From: DEBORAH NORRIS [REDACTED]
Sent: 31 August 2014 21:14
To: Janice Chapman
Subject: Re: FP/132/14/HH - Erection of a pagoda style carport at 10 Grafton Avenue, Felpham

Sent: Friday, 29 August 2014, 16:05
Subject: FP/132/14/HH - Erection of a pagoda style carport at 10 Grafton Avenue, Felpham

FRONT ELEVATION DRAWN TO 1:50 SCALES

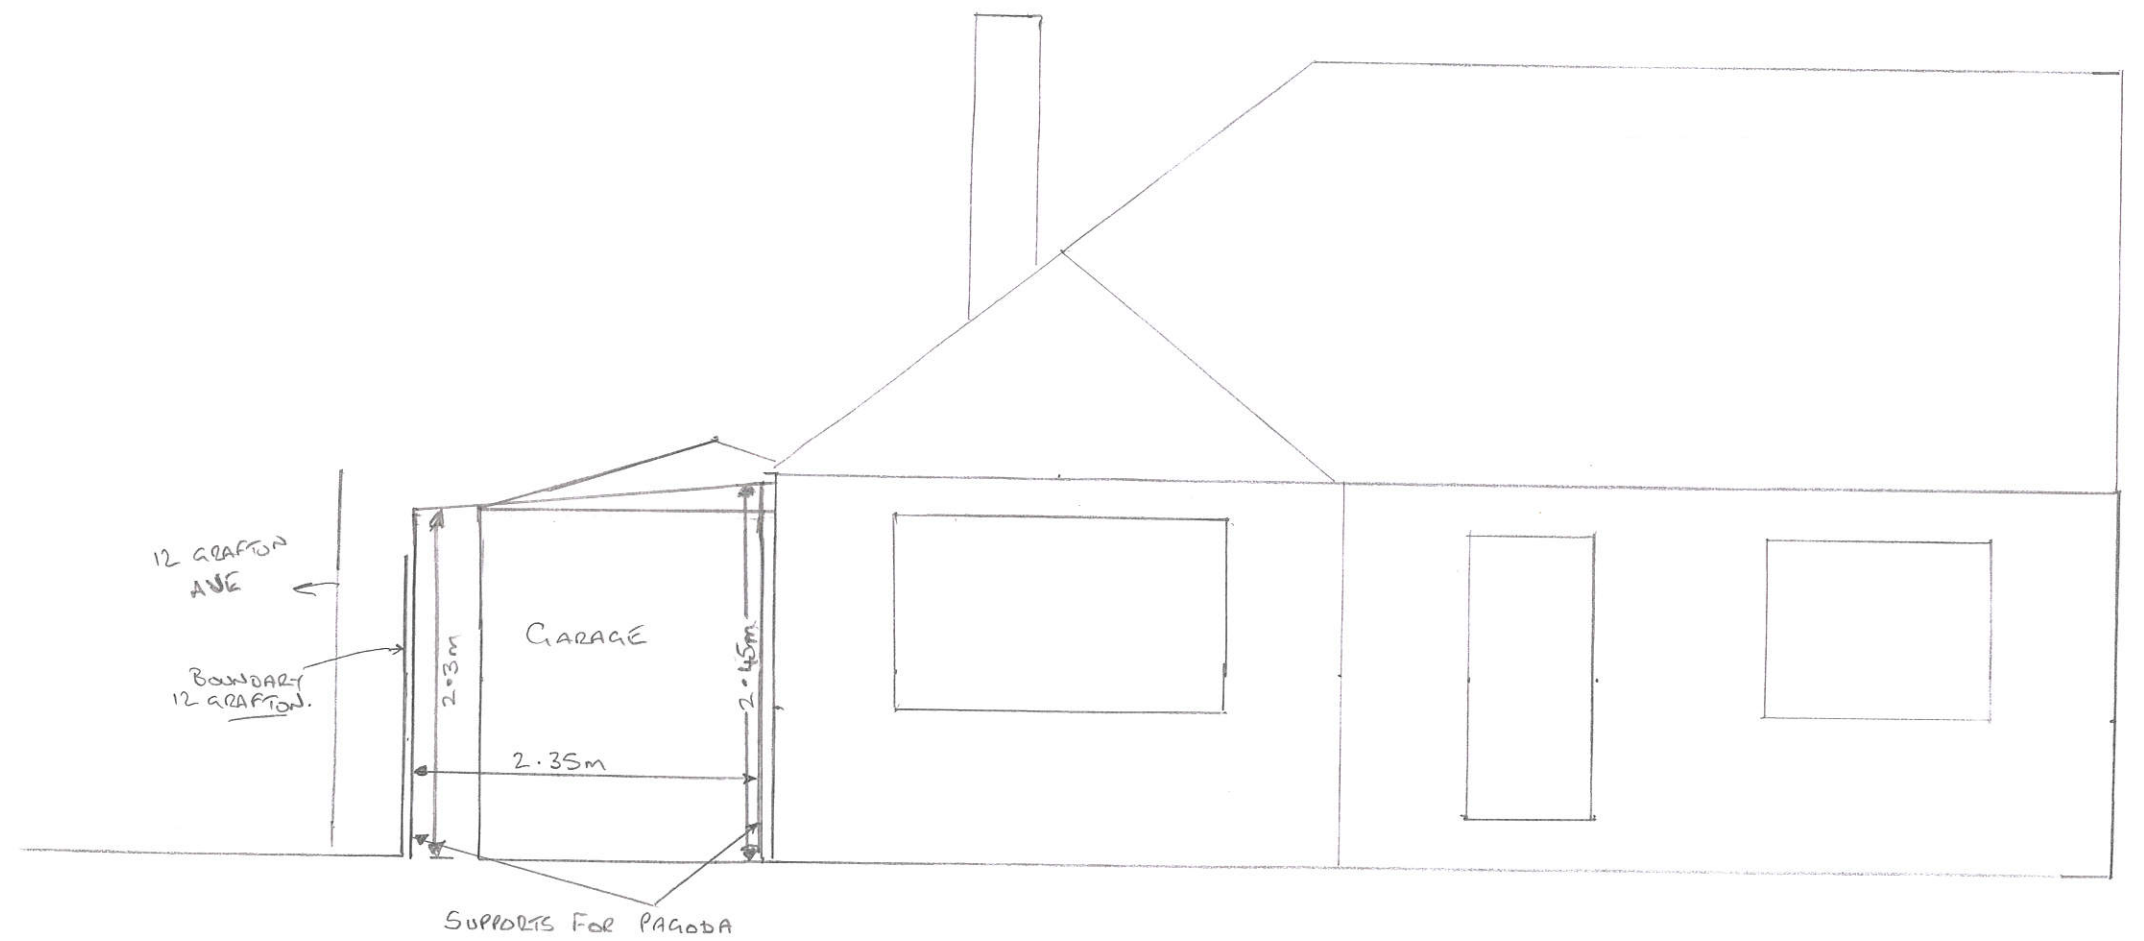
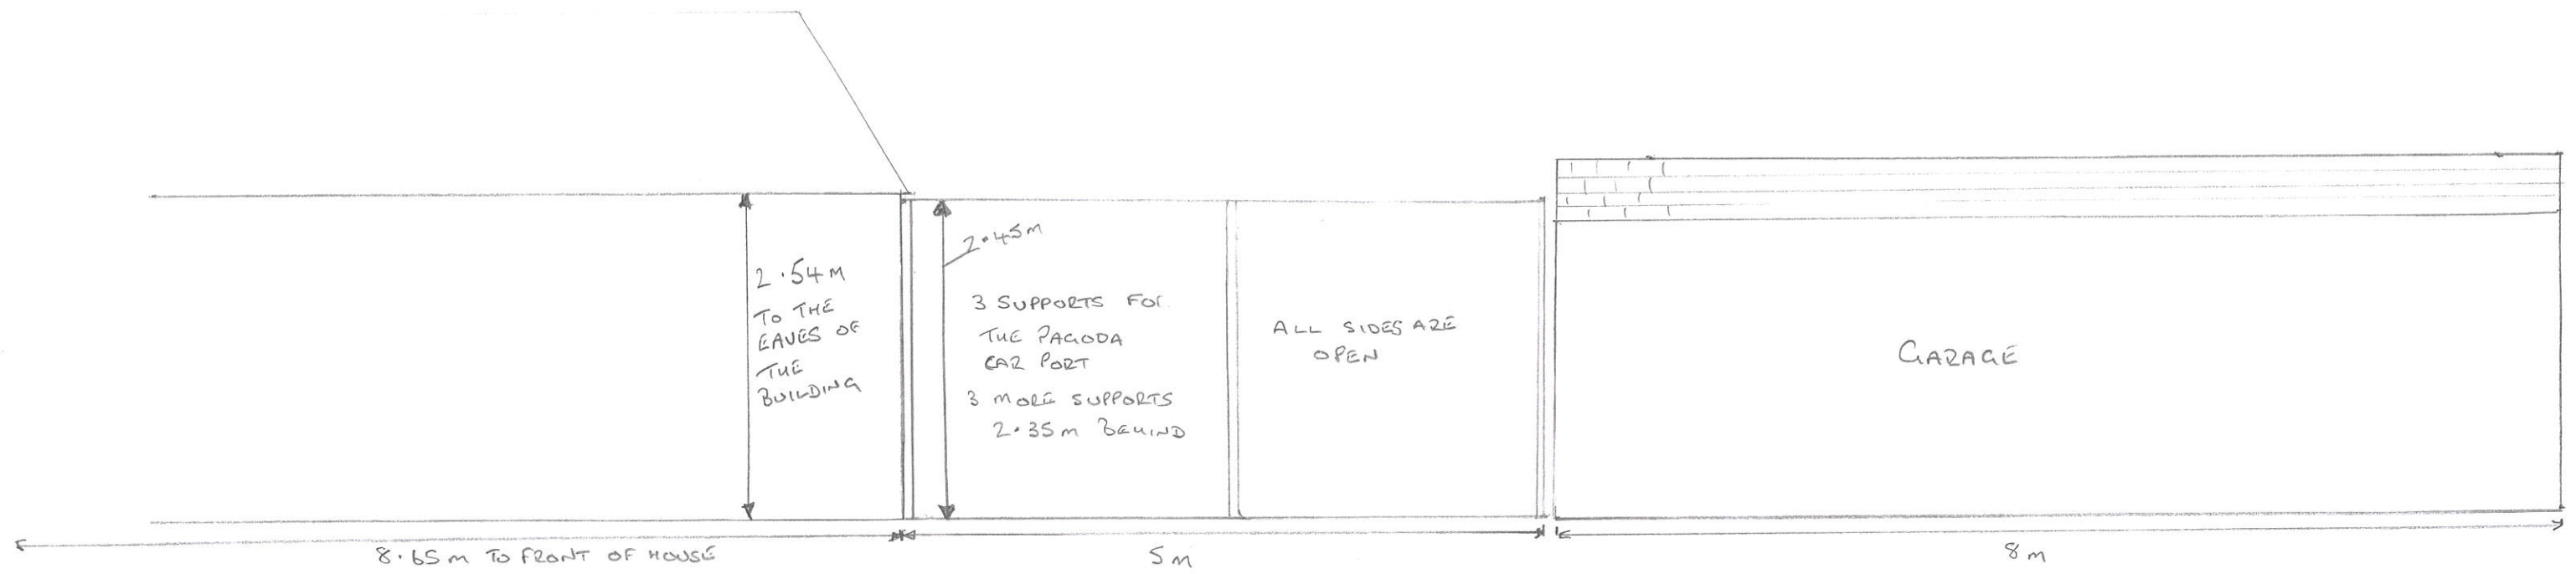
The application refers to timber supports for the car port but does not make any reference to the roof covering.

Please confirm.

We can confirm that the roof covering will be polycarbonate sheets, which will be fixed in sections, allowing for those nearest the house to be removable for any maintenance work to the property.

The sheeting will end before the boundary line and drain into guttering, which will be fixed underneath and will connect to the existing garage downpipe.
